Darlington Lane, Darlington

Thank you for requesting a 10 km/h shared zone on Darlington Lane, Darlington

Roads and Maritime has reviewed your application for a 10 km/h shared zone on Darlington Lane, Darlington.

Appendix A Darlington In shared zone – schematic layout

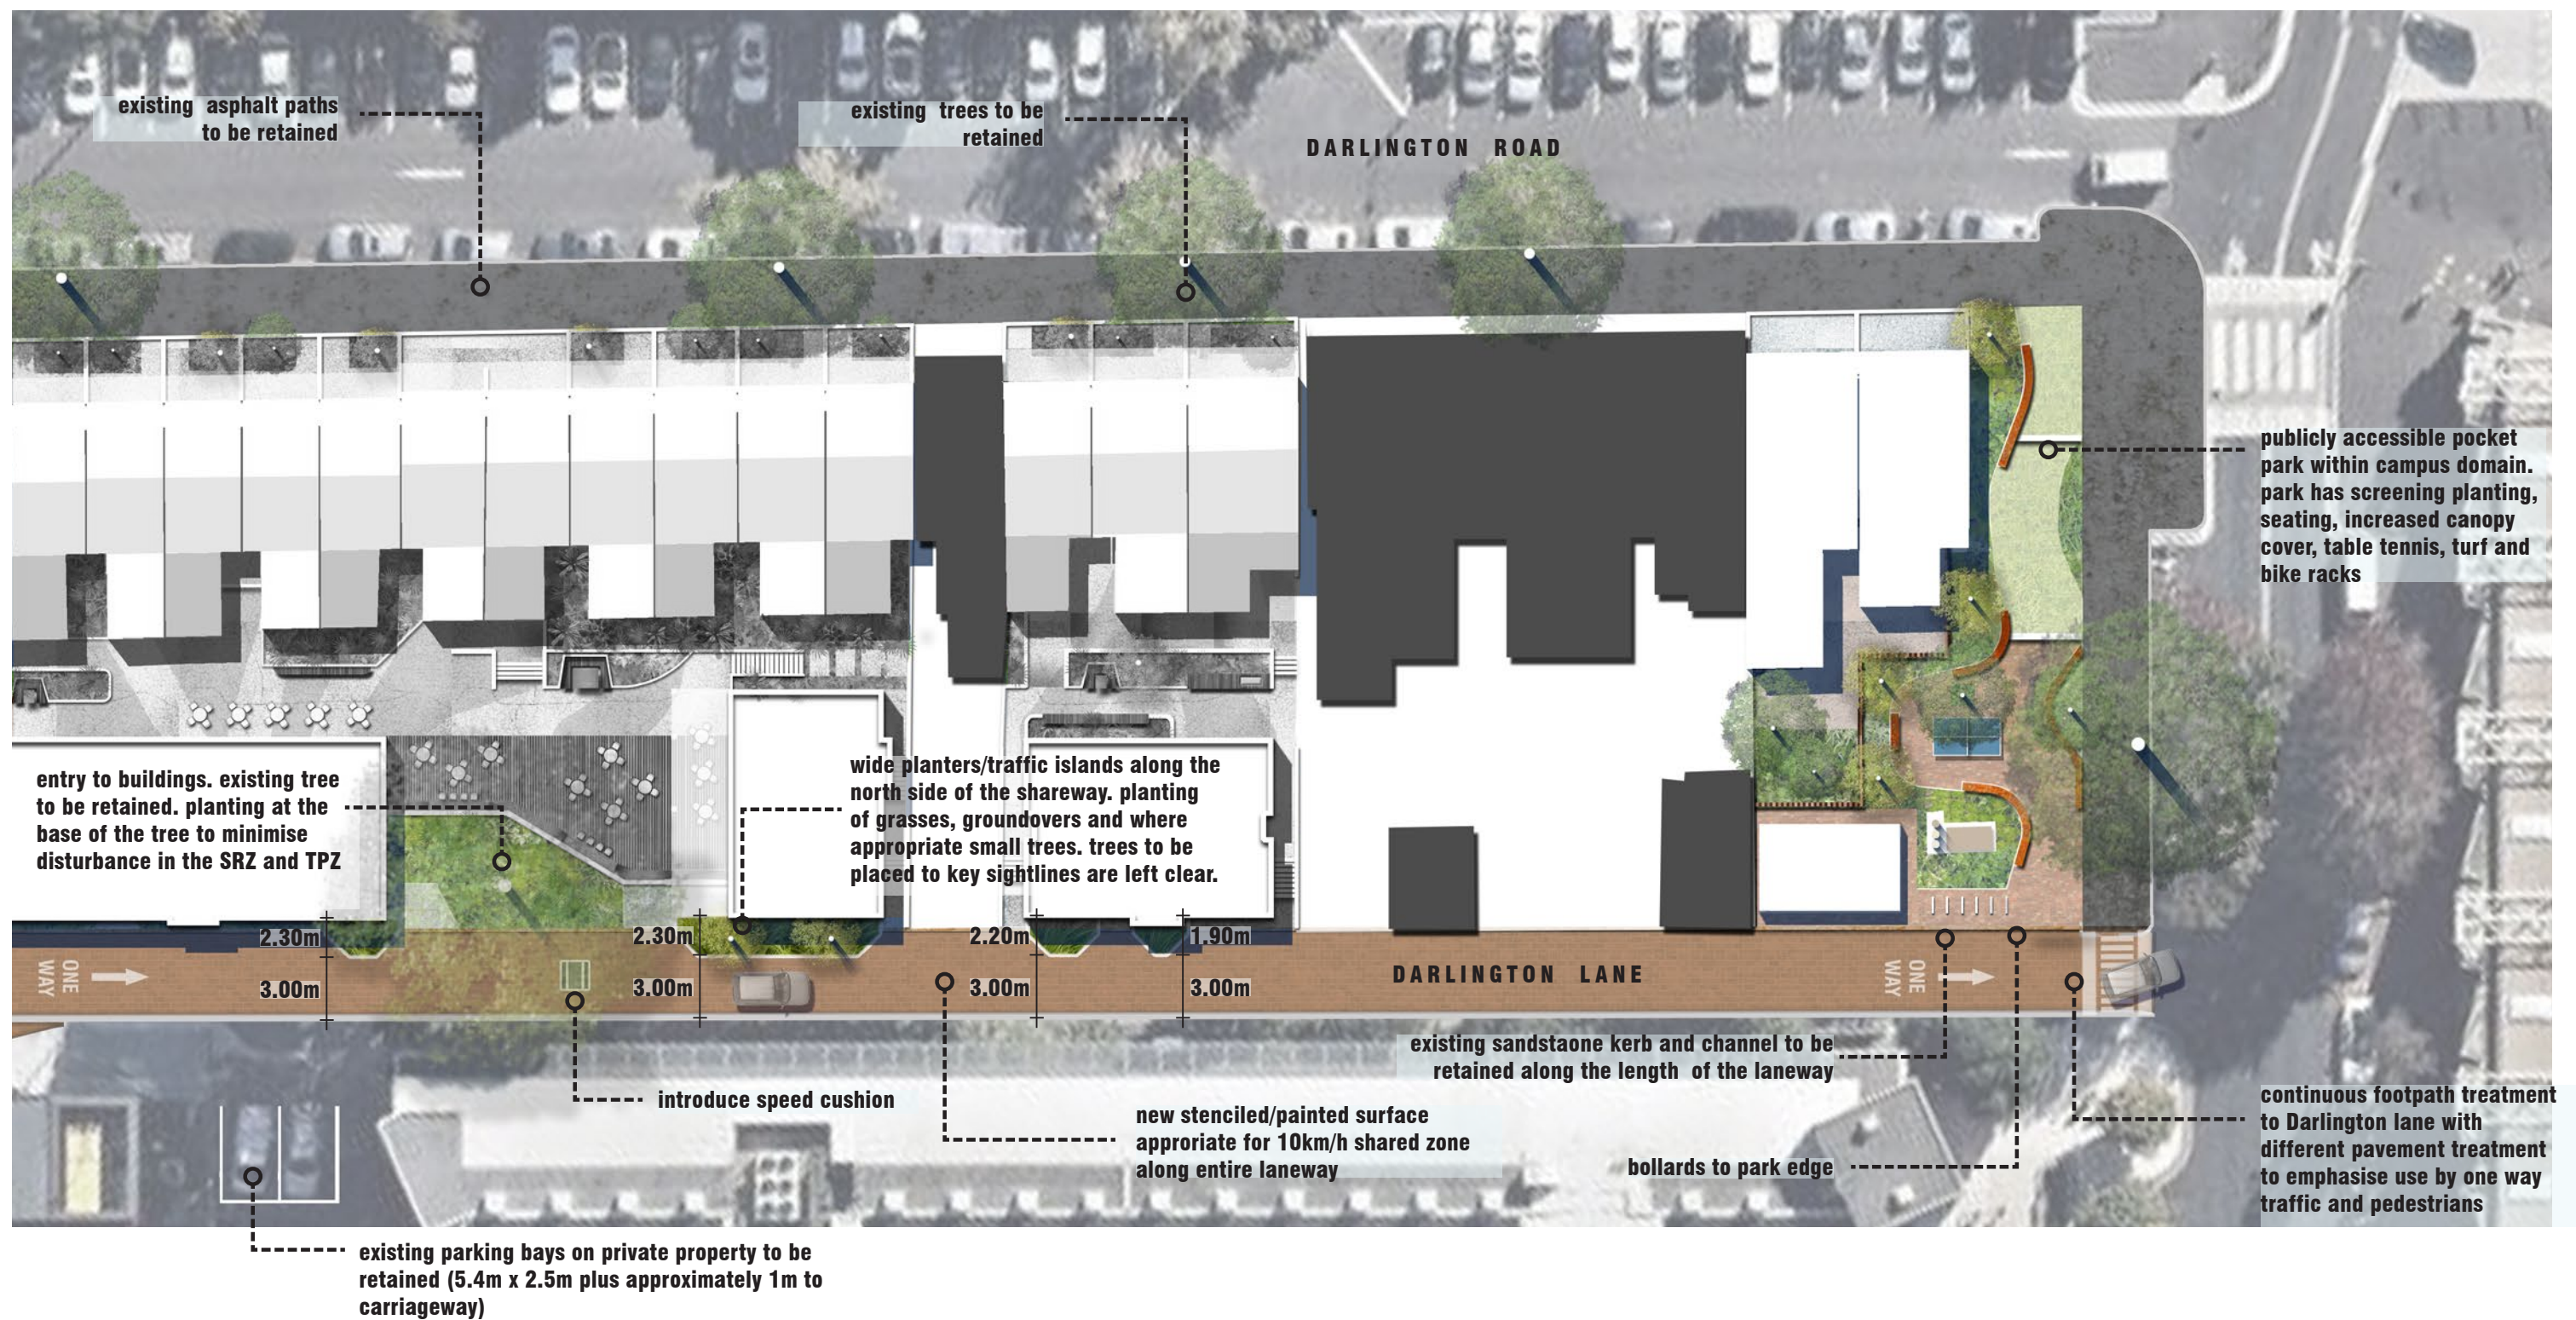
Roads and Maritime is granting approval of the proposed shared zone conditional on the following:

- Council to confirm that a stage 4 Road Safety Audit identifying issues pertaining to vehicle speeds and pedestrian safety (including mobility and vision impaired safety) has been undertaken on Tung Hop Street and all deficiencies addressed.
- Council to confirm that a lighting audit has been undertaken to ensure appropriate lighting is considered for safety and security.
- Council to confirm that all relevant Traffic Committee approvals have been completed.
- Council to confirm that all relevant Community Consultation have been completed.
- Council to advise Roads and Maritime when all proposed works are completed.
- That and proposed parking on Darlington Lane must be within marked bays with regulatory signs.
